SUBJECT: SFD2404-0104
SINGLE FAMILY DWELLING

Here are the results of all Inspections located at **3492 OLIVIA RD:**

Inspection Type: ROUGH IN
Scheduled Date/Time: 1/6/2025
Completed Date/Time: 1/6/2025
Inspector: Daniel L Floyd
Result: DISAPPROVED

**PLACEMENT PLAN**

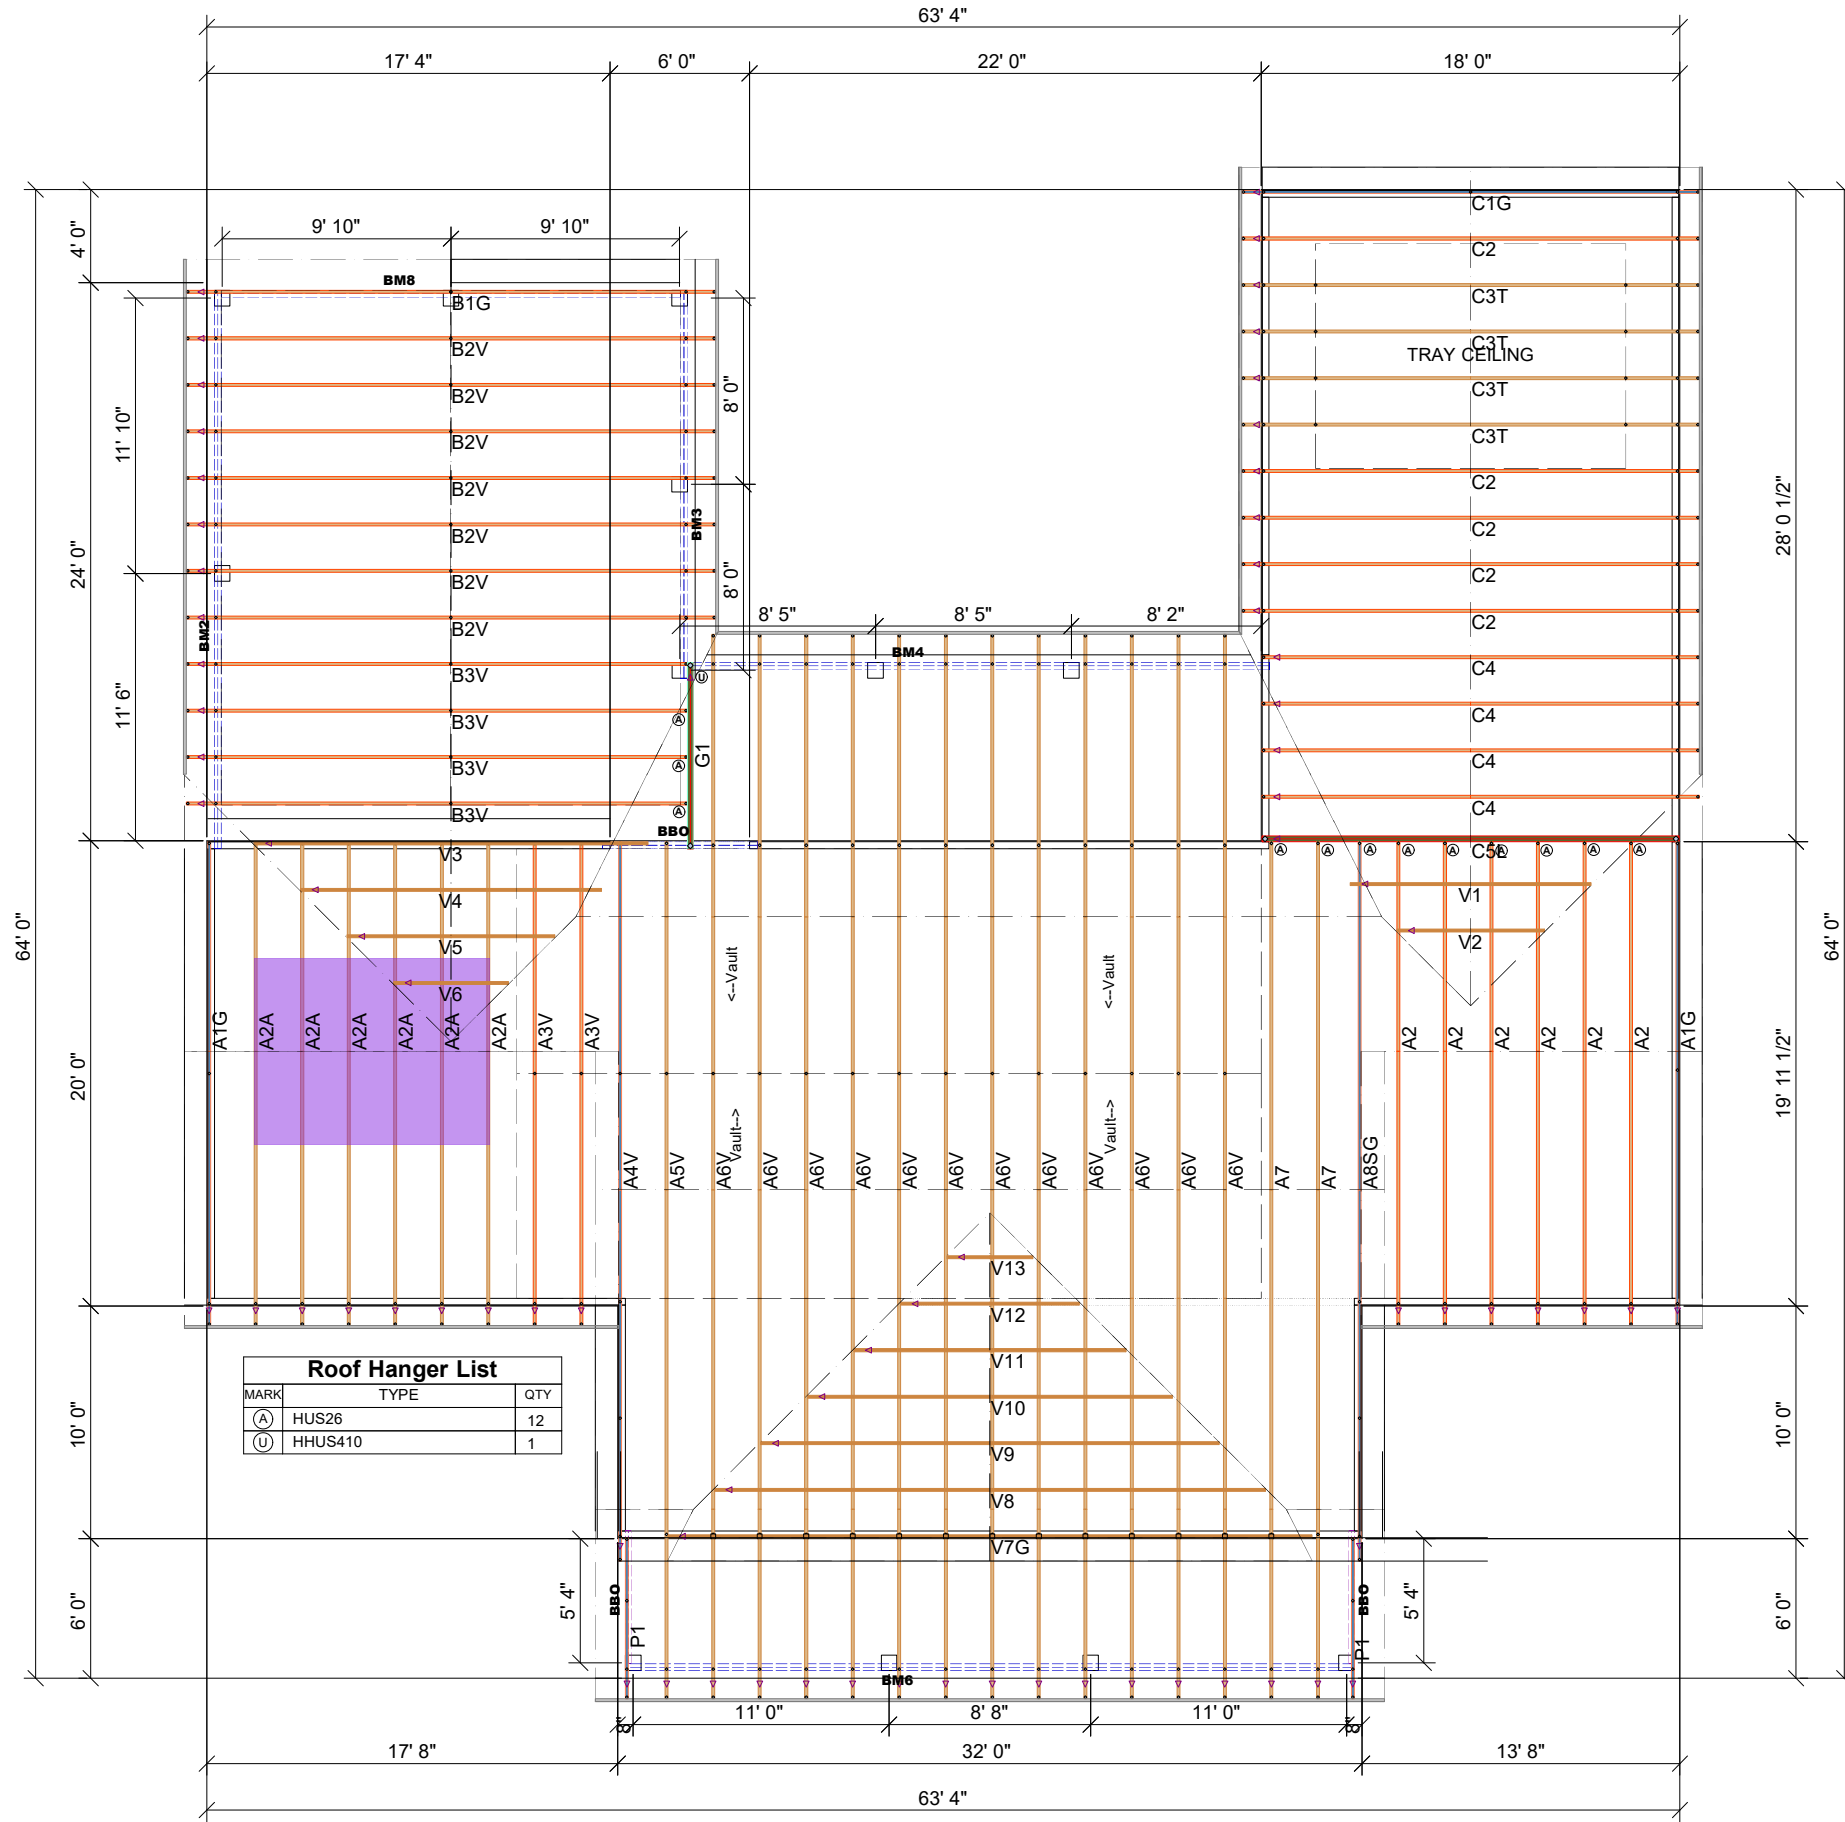
1. 6ft window in kitchen needs 2 kings studs each side also window not installed at time of inspection but was covered 2. Missing a piece on the top plate under a truss at back door in kitchen area 3. Need to strap top plate where it's notched out for the porch beam 4. Seal top of chase between master bathroom and other bathroom 5. Missing nails in hangers above master bathroom 6. Fire stop penetration for thermostat 7. Need 24" straps on each side of the front door header for the broken top plates 8. Dryer vent not completed 9. Missing nails in hangers on the back porch 10. Electrical wires come out of the house below the ceiling line on the back porch 11. The hangers on c5l are not the correct hangers truss docs call hus26 hangers and they need to have 16d nails 12. Girder truss needs to be nailed together per truss sheet 13. Double 2x10 on each end of the front porch have no support under them at lvl 14. Missing nails in the hurricane clips on rear wall 15. Missing hurricane clips on the front and back porch 16. Anchor bolts need to be in the center 1/3 to the right of the front door 17. Need 2 anchor bolts per member in the bathroom by laundry
